**SUBJECT: BRES2303-0028**  
**BUILDING RESIDENTIAL**

Here are the results of all Inspections located at **158 EDMONT TER:**

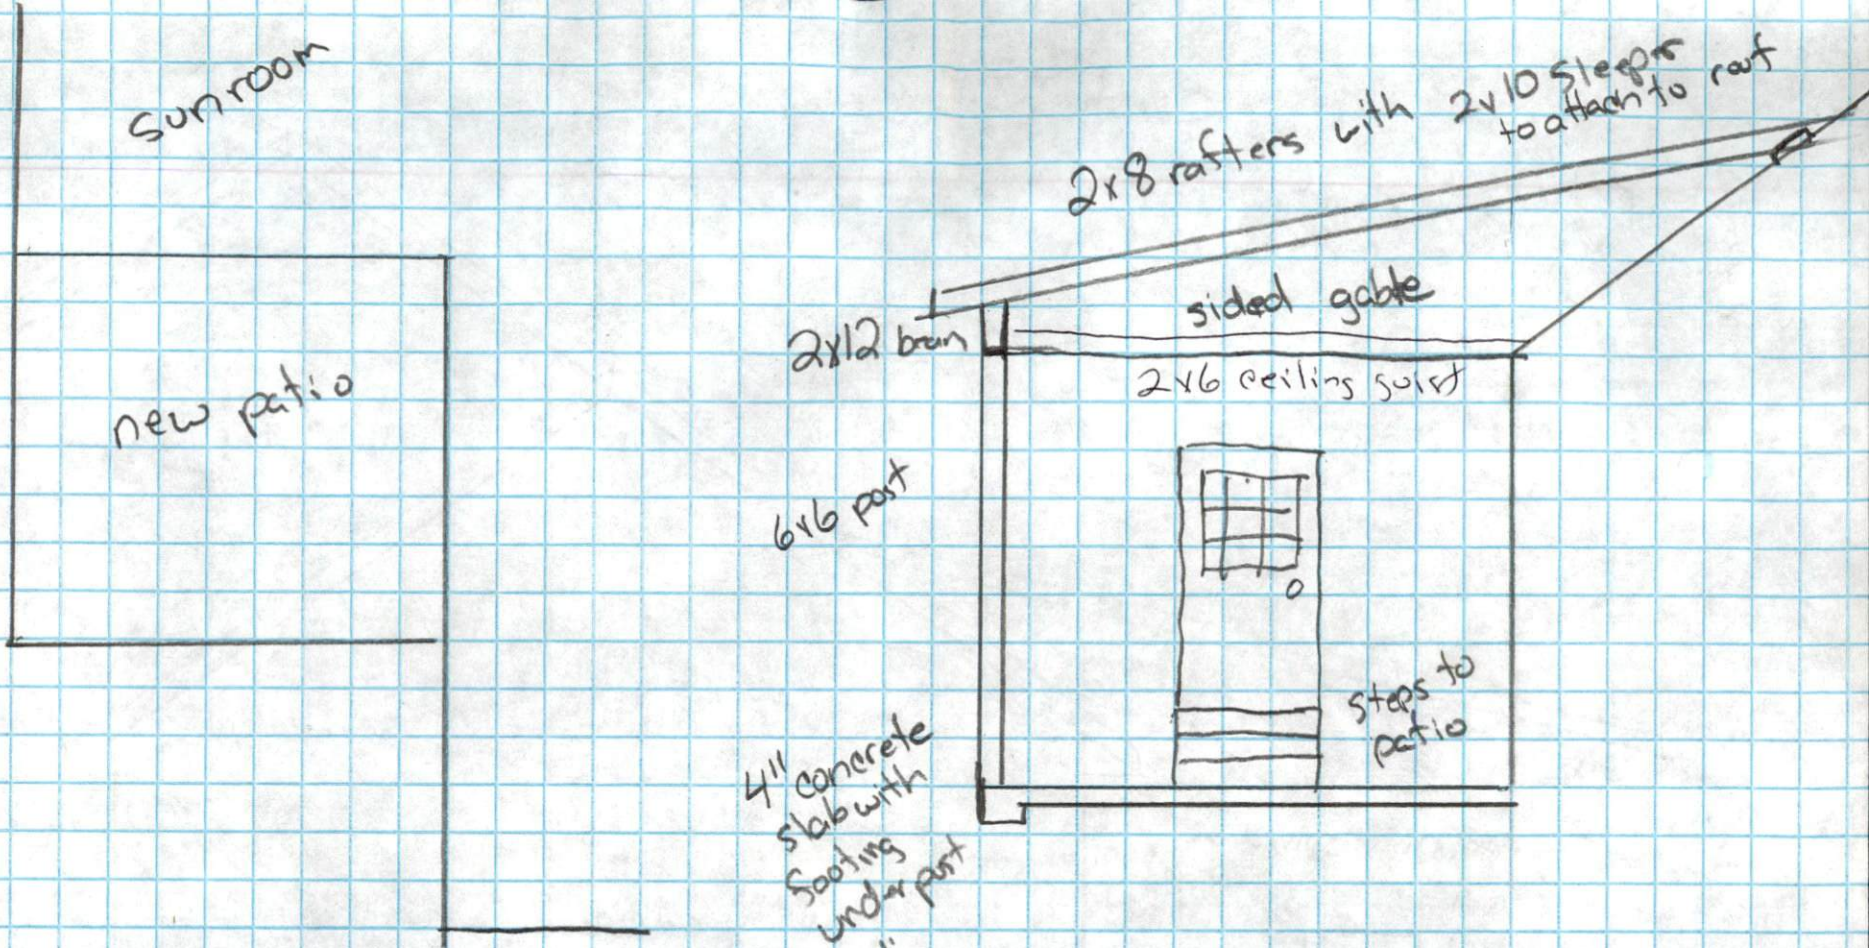
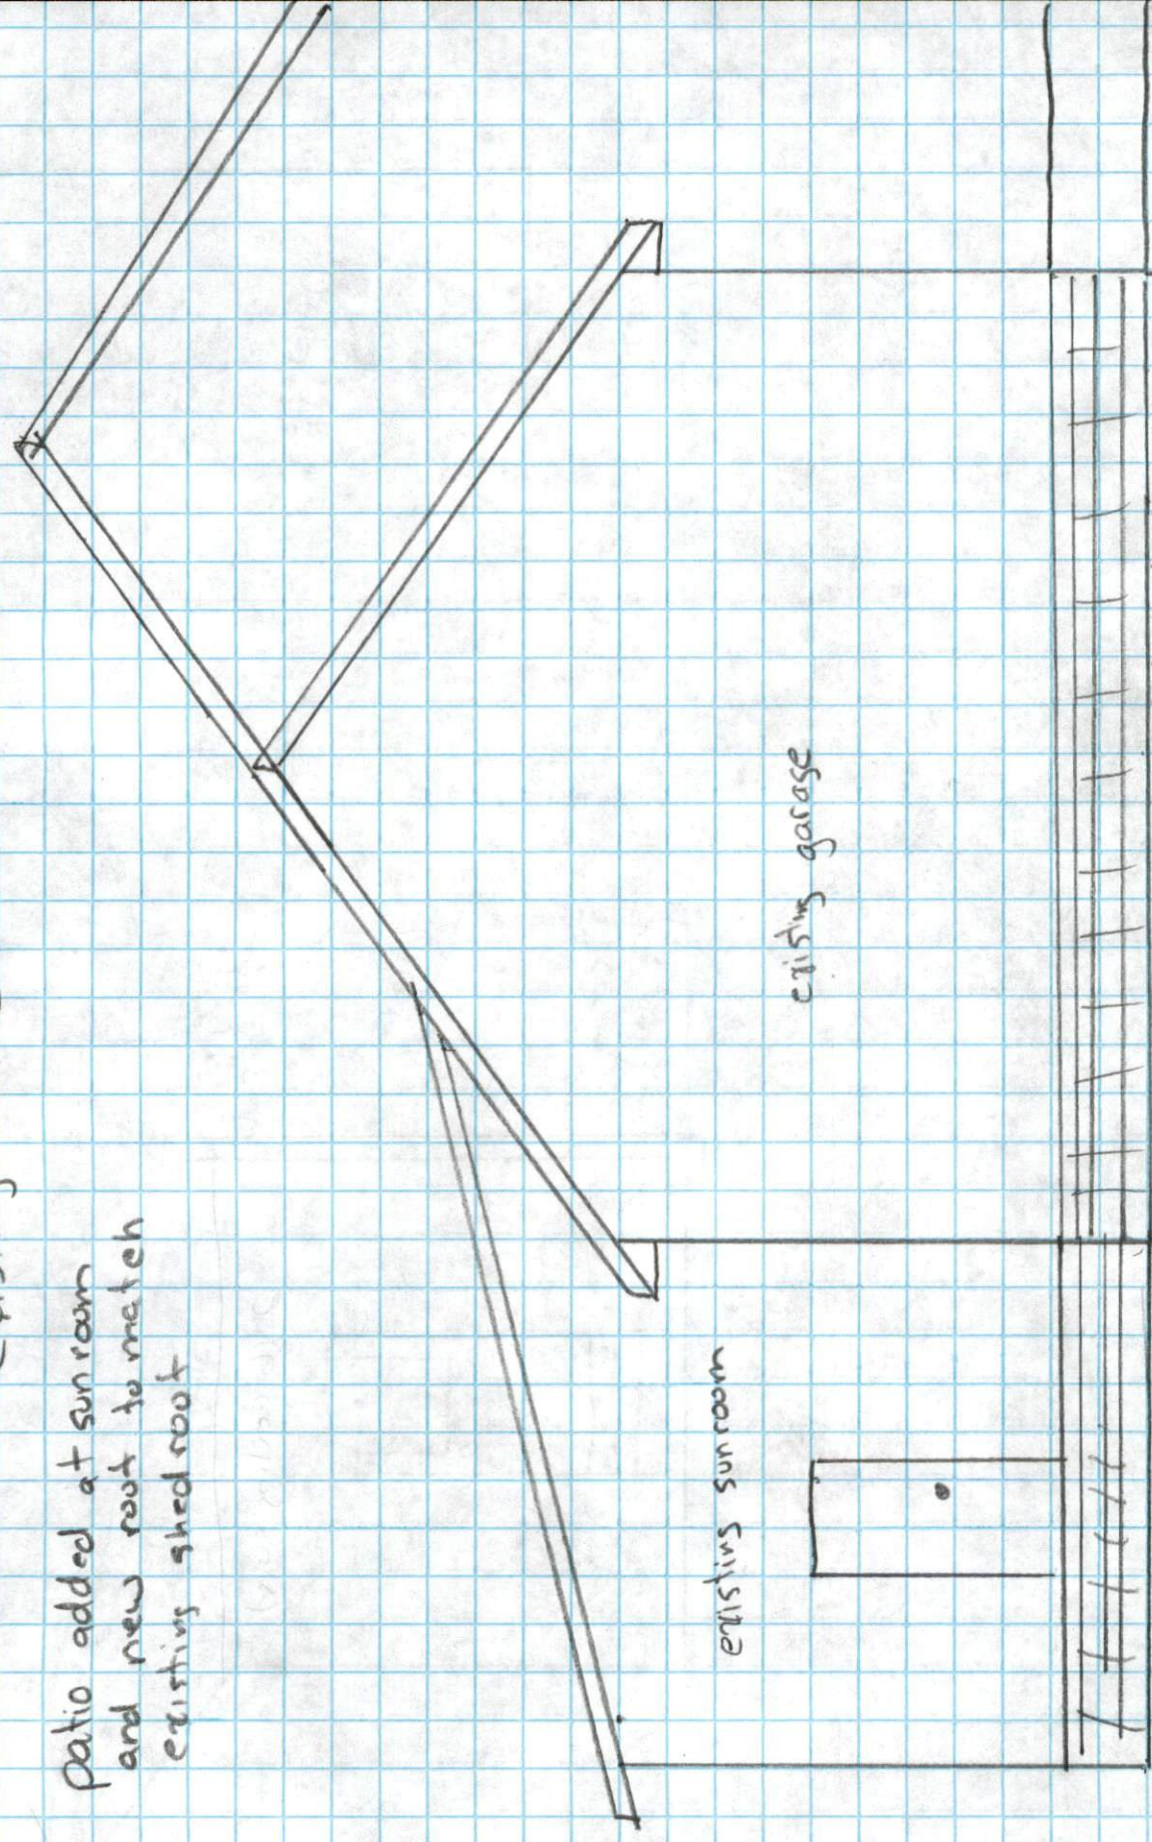
Notes: Unable to verify attachment of post at base. Rafter and ceiling joist cuts do not meet code.
